Planning Application Ref: K/51/21/PL

Location: 47 Golden Avenue, East Preston, BN16 1QX

Description of works: Erection of 1no. detached dwelling and integral garage. This site is in CIL Zone 4 and is CIL Liable as new dwelling

TITLE: Street Scene and Topographical Survey.
As Surveyed 23.07.2021.

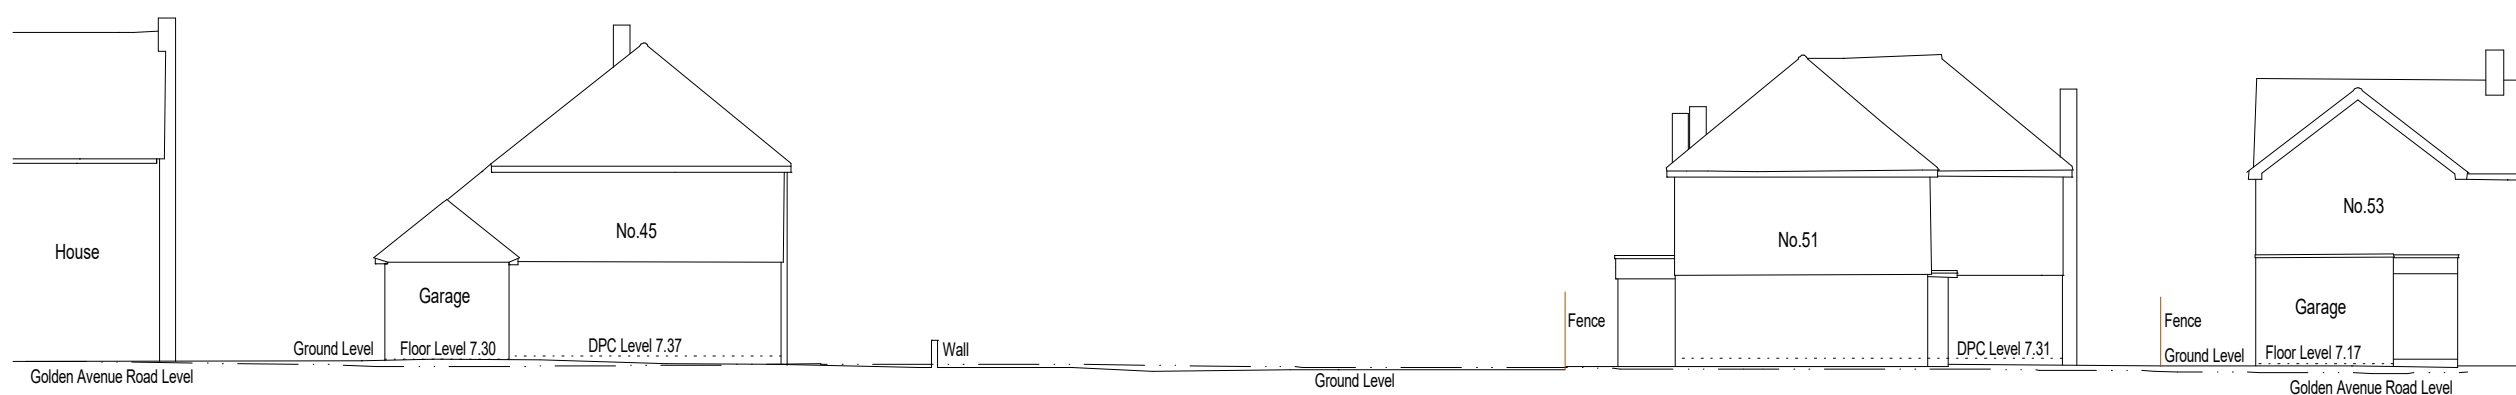
- I have considered this application by means of a desktop review, using the information and plans submitted as well as online resources.
- It has been stated (application form, sect.10) that there are no trees or hedges on land adjacent to the proposed development site that could influence the development or might be important as part of the local landscape character. That may well be the case, although aerial photography and architect's plans show several off-site trees which may overlap the site (by crown spread and/or root growth) so could be adversely affected by these proposals.
- There is no supporting arboricultural information submitted with the application - a requirement of BS5837:2012. As such, were this application to now proceed, we will not have sufficient information to guarantee any trees and hedges have been adequately considered and would be protected.

1. The applicants will need to employ the services of an Arboricultural Consultant to carry out a tree survey exercise and then prepare an Arboricultural Impact Assessment (AIA) which must be inclusive of; a 'Tree Survey Schedule', a 'Root Protection Area (RPA) Schedule' and a 'Tree Constraints Plan' – with the trees accurately plotted on same.
2. In the event that an RPA of any tree which is proposed for retention overlaps the development then BS5837:2012 requires that the Detailed Planning Application is accompanied by an Arboricultural Method Statement (AMS) and most importantly a Tree Protection Plan – to both describe and illustrate the mitigation measures which are to be employed to ensure that the trees survive without detriment to their vigour and vitality and are given adequate protection both above and below ground.
